PLANNING CONSULTATION RESPONSE

Application No	2026/0371
Proposal	Erection of two storey side extension, single storey rear and side extension and single storey front porch.
Address	2 Kensington Road, Old Town, Barnsley, S75 2TX
Date of Consultation Reply	15.07.2026
Consultee	Charlie Atkinson Design & Conservation Assistant

Proposed Elevation - A (1:100)

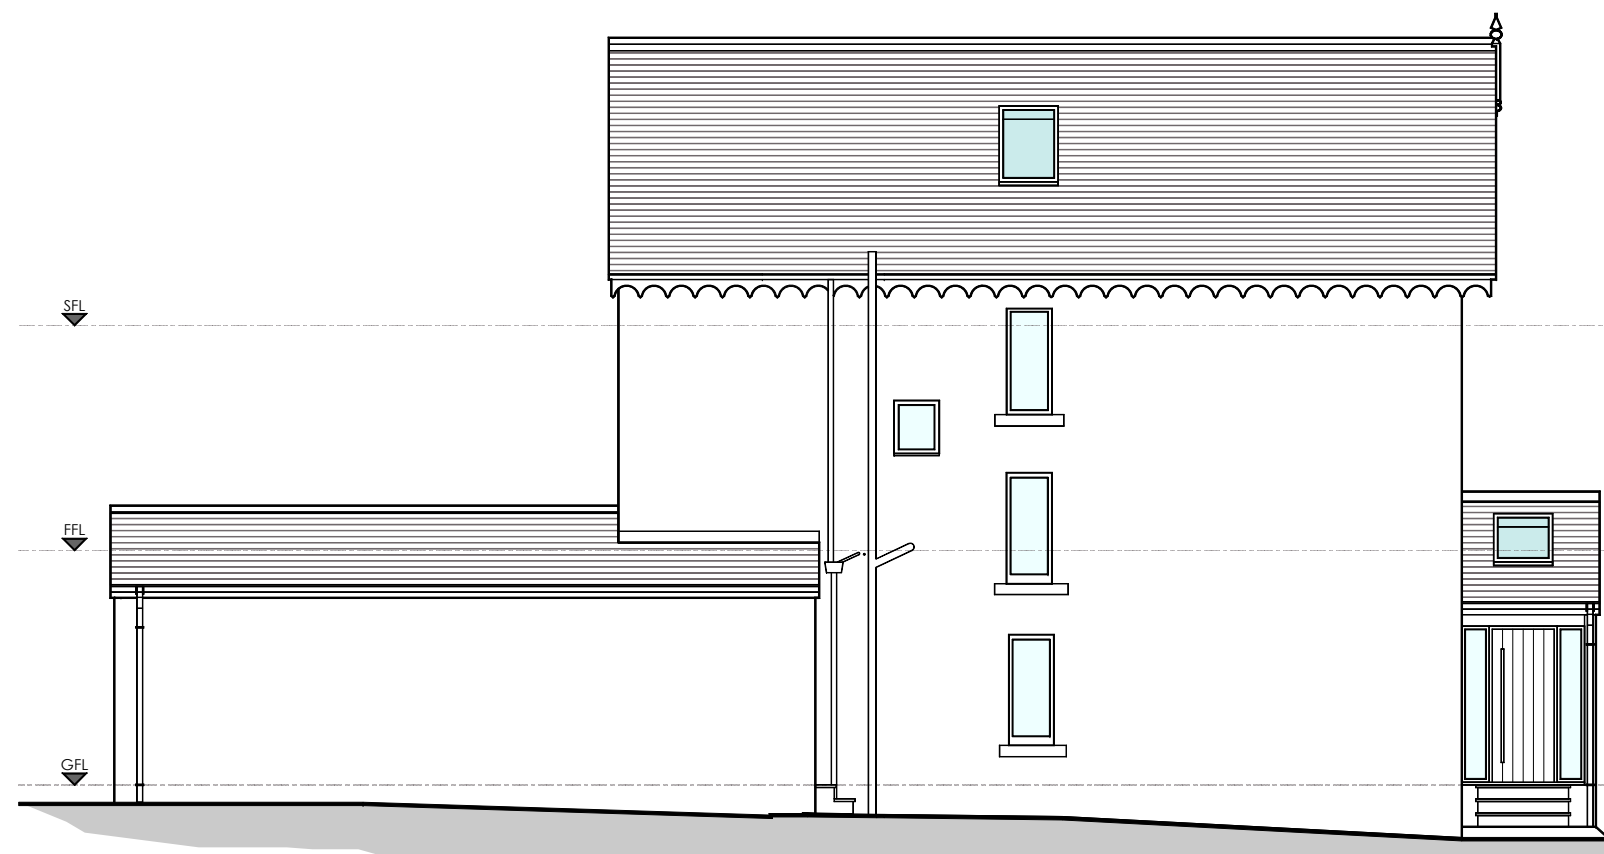
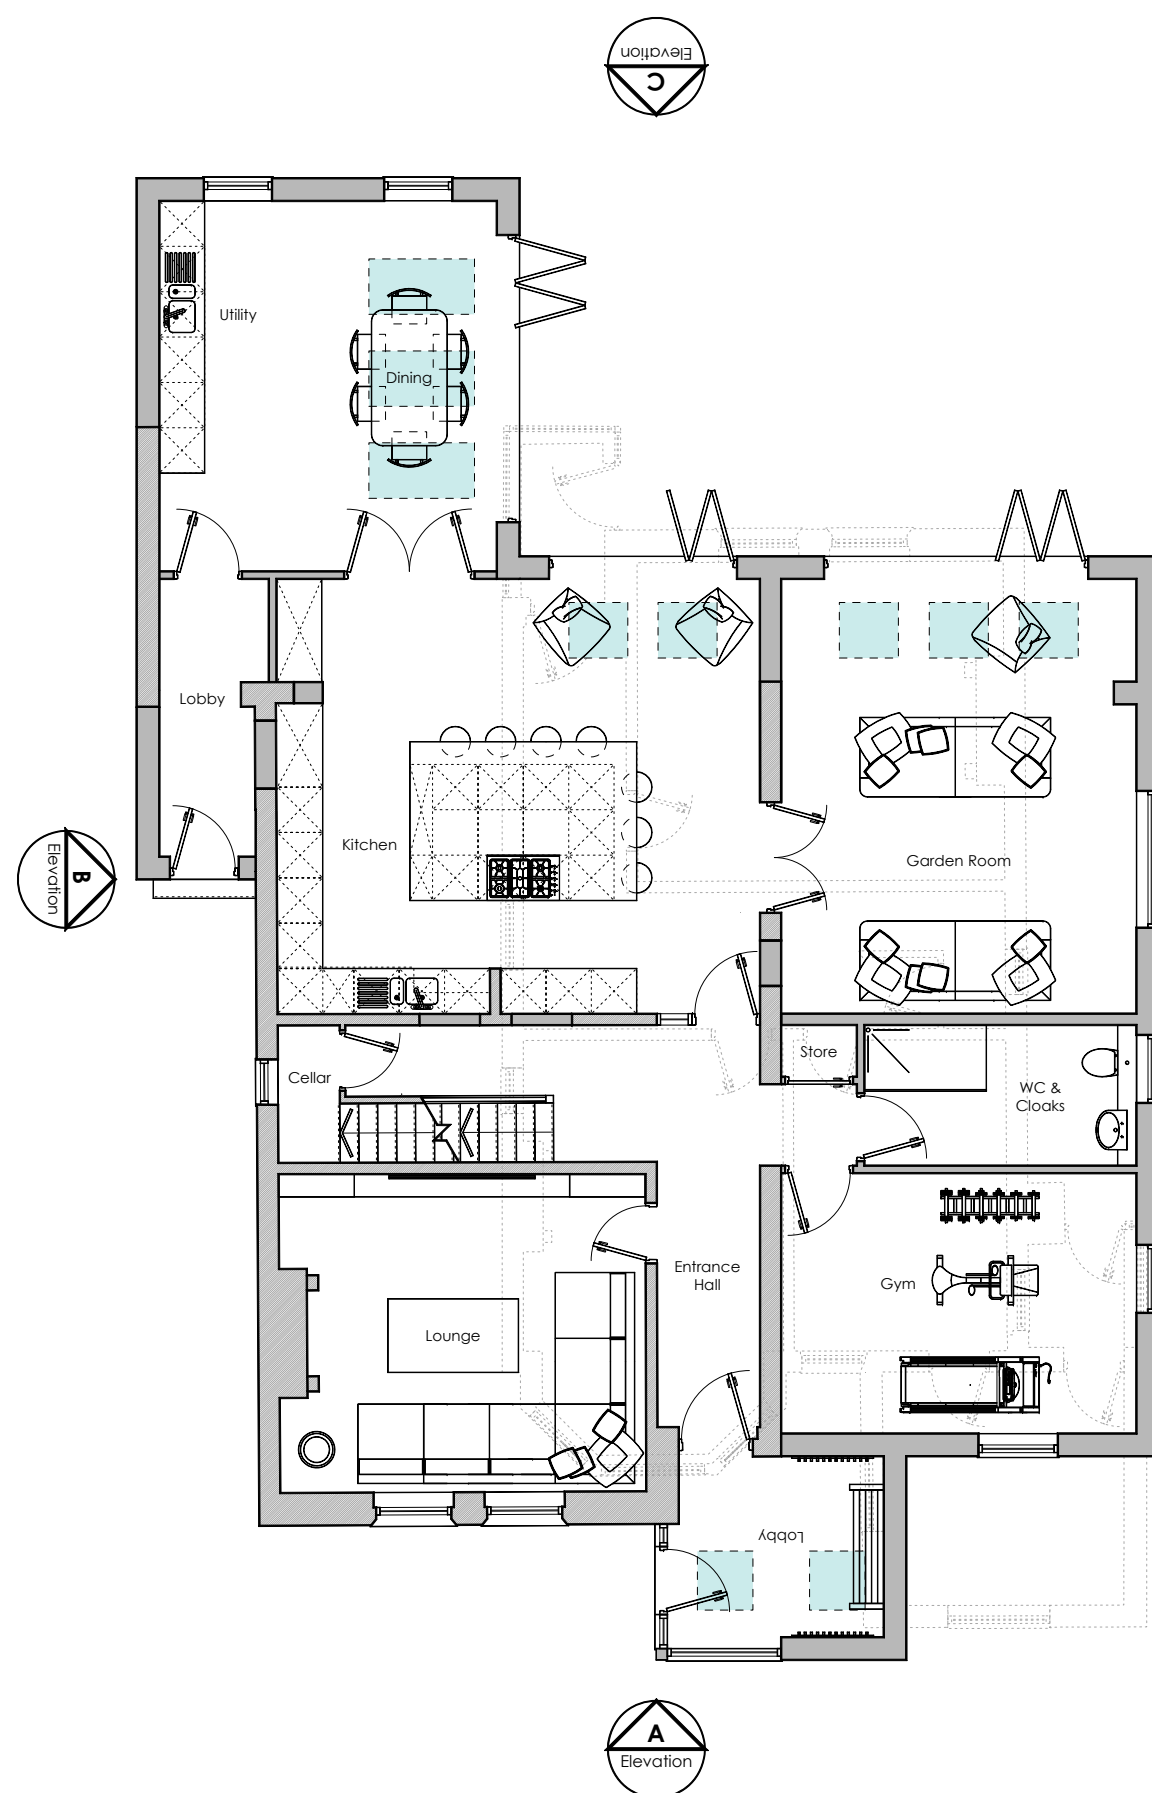
From a conservation perspective the proposed development is considered acceptable. The extensions retain the overall character of the building and are sympathetic to its surroundings and the setting of the conservation area. In general, they are proportionate and sympathetically scaled and adequately suit the host dwelling. Importantly, the proposed extensions are primarily located to the west of the property and are not considered to result in harm to the significance or appreciation of the historic wall to the east. Whilst it is assumed that materials will match the existing as indicated within the application, conditions are recommended below to secure the building's finish.

- The facing stone to the proposed development shall match the existing building in terms of colour, general grain size, type of face dressing, and method of coursing.
- The roof materials to the proposed development shall be good quality artificial grey slate or natural to match the existing.
- Rainwater goods including guttering and down pipes shall be black.
- The windows shall be aluminium and white in colour.
